Re: Western Sydney Stadium - Response to Stage 2 DA Comments
Attachment One – detailed comments
'Traffic & Transport'

STAGE 2 DESIGN APPROVAL
PRECINCT CONNECTIONS DIAGRAM

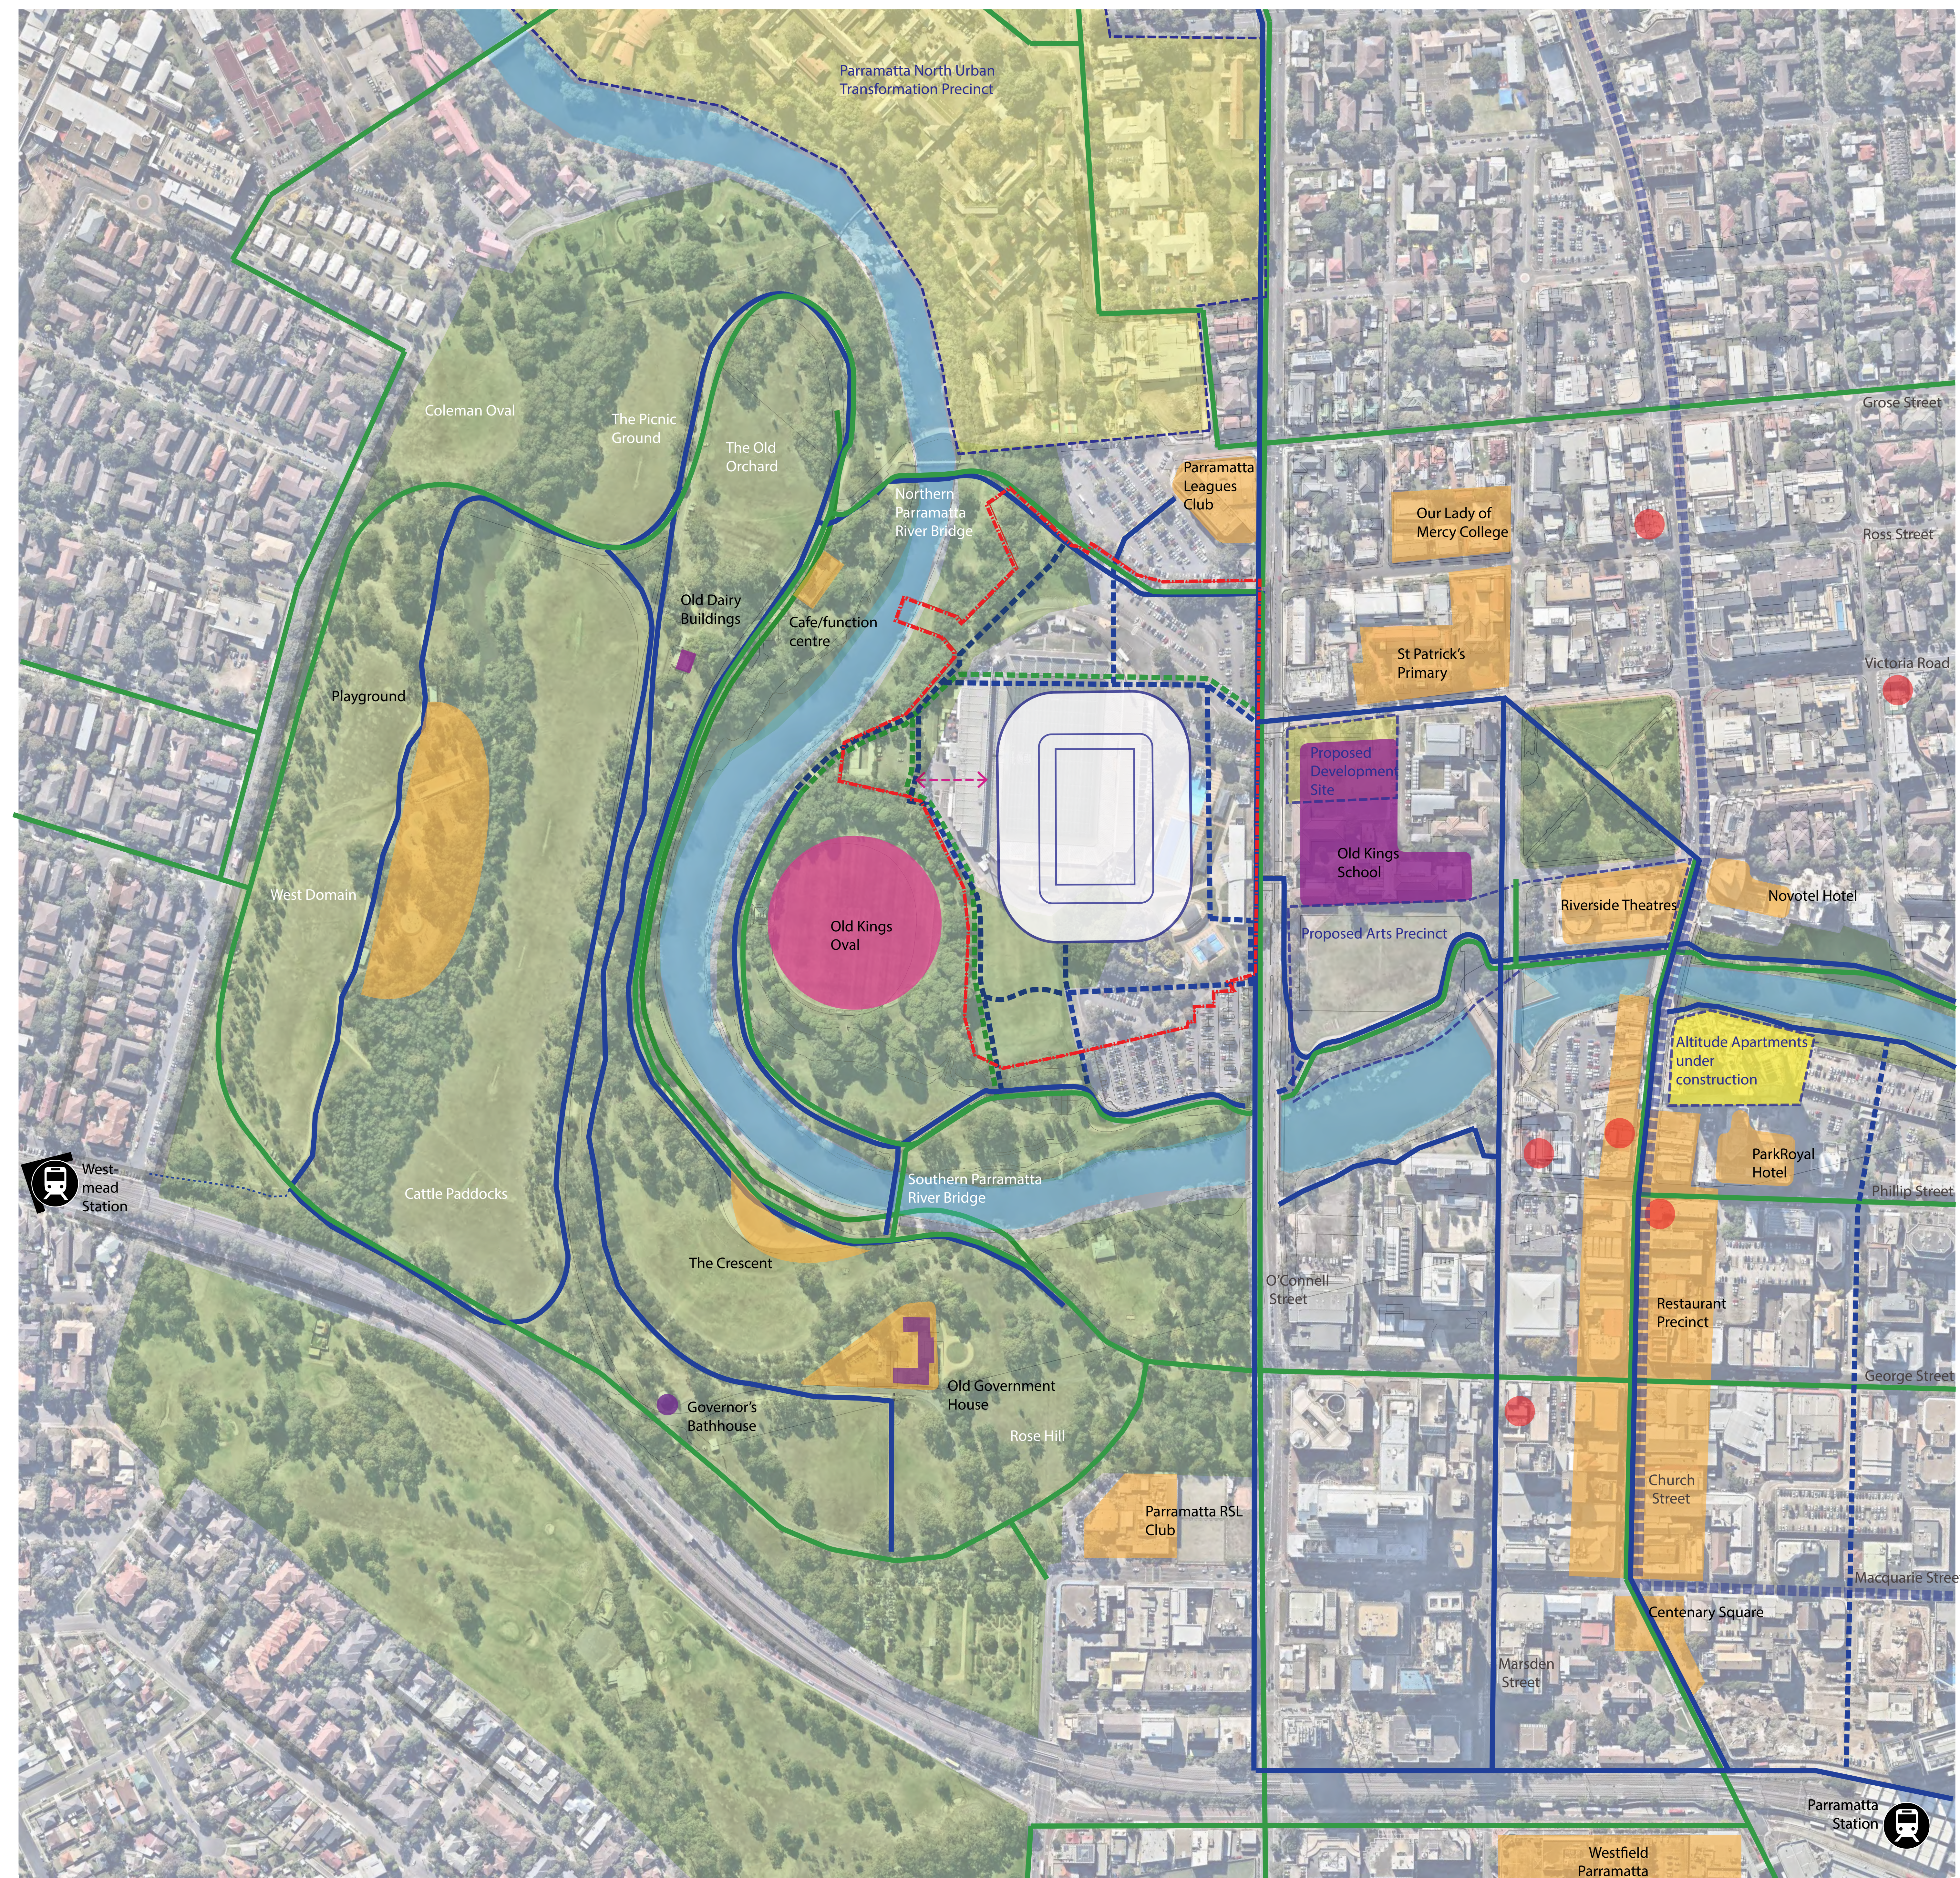
The precinct wide connections diagram (page 5 of Design Report) should include O'Connell Street as a primary link provided other origins such as PNUT and the leagues club. This should be reflected in the public domain design.

Diagram updated – Refer page 5 of the Design Report
